**United Utilities Water Limited
Developer Services & Planning**
Warrington North WWTW
Barnard Street off Old Liverpool Road
Gatewarth Industrial Estate
Sankey Bridges
Warrington
WA5 1DS

Your ref: 3/2015/0355
Our ref: DC/15/1621
Date: 27/05/2015

Location: Land off Parsonage Ave, Ribchester
Proposal: Discharge Of Condition 1-Surface Water Drainage

Engineering Layout

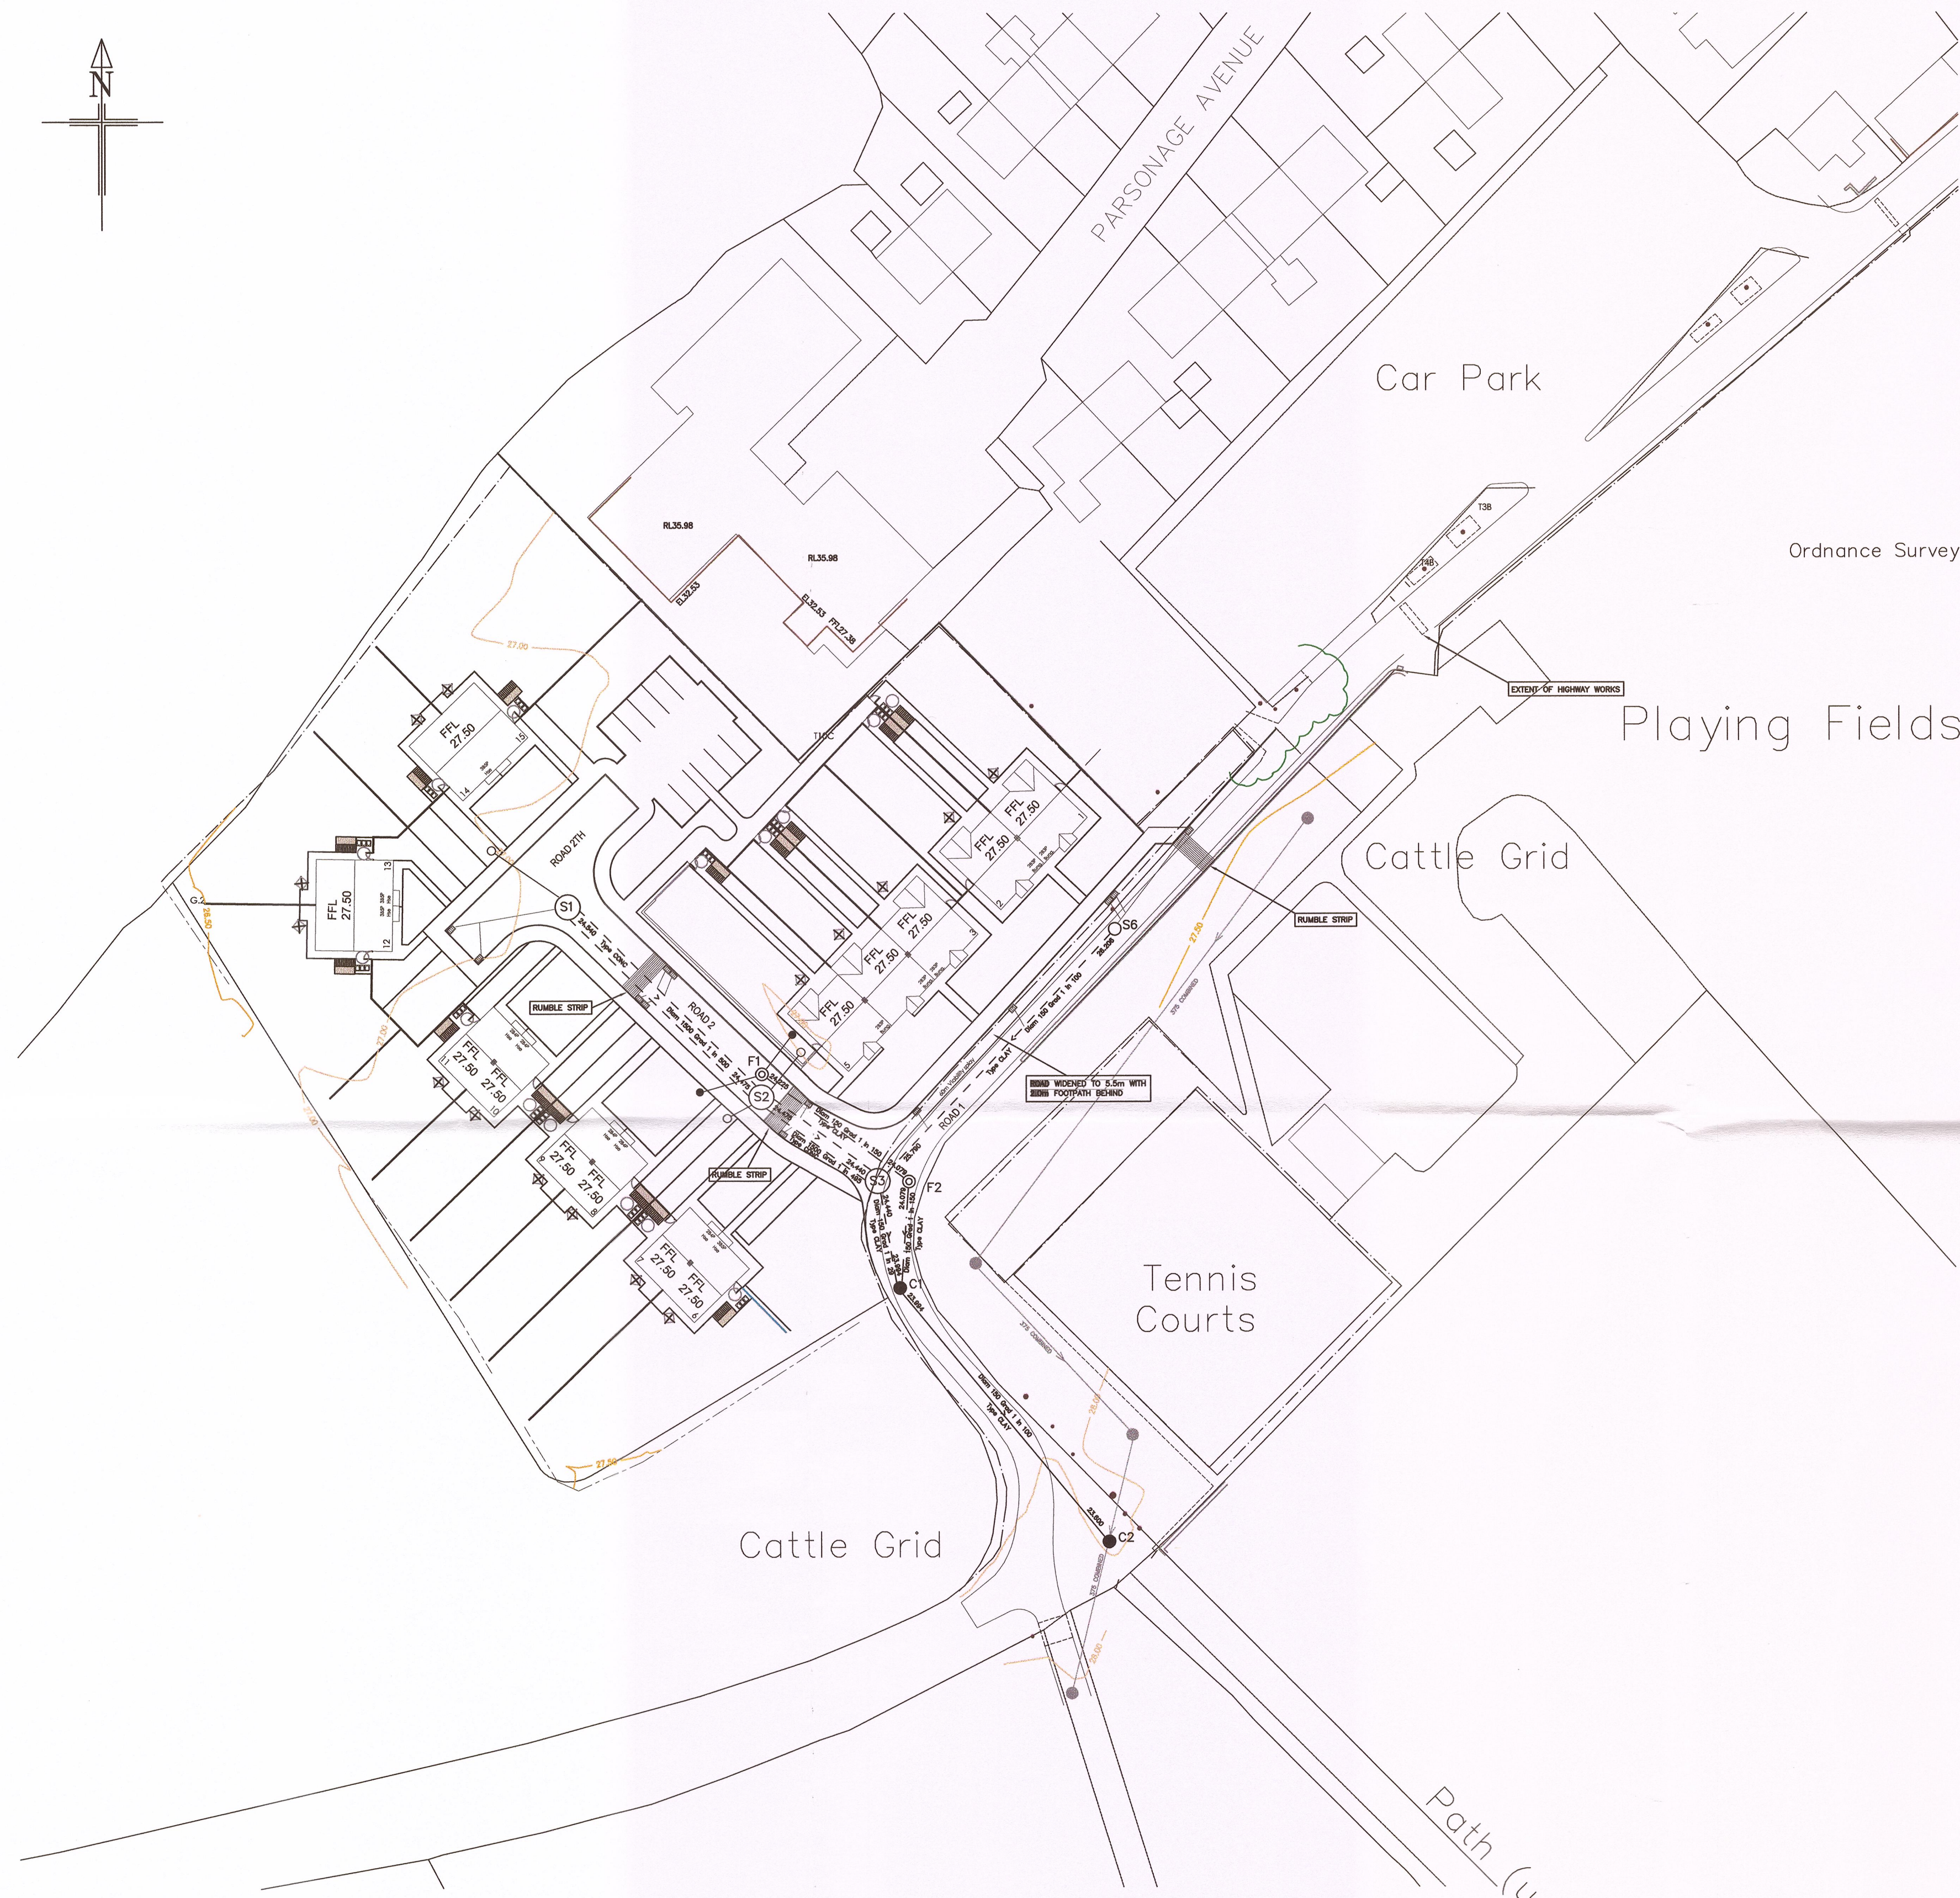
With reference to the above planning application, United Utilities unfortunately cannot discharge the condition as the developer intends to drain highway drainage from the existing highway into the public sewer and United Utilities have no responsibility to accept this.
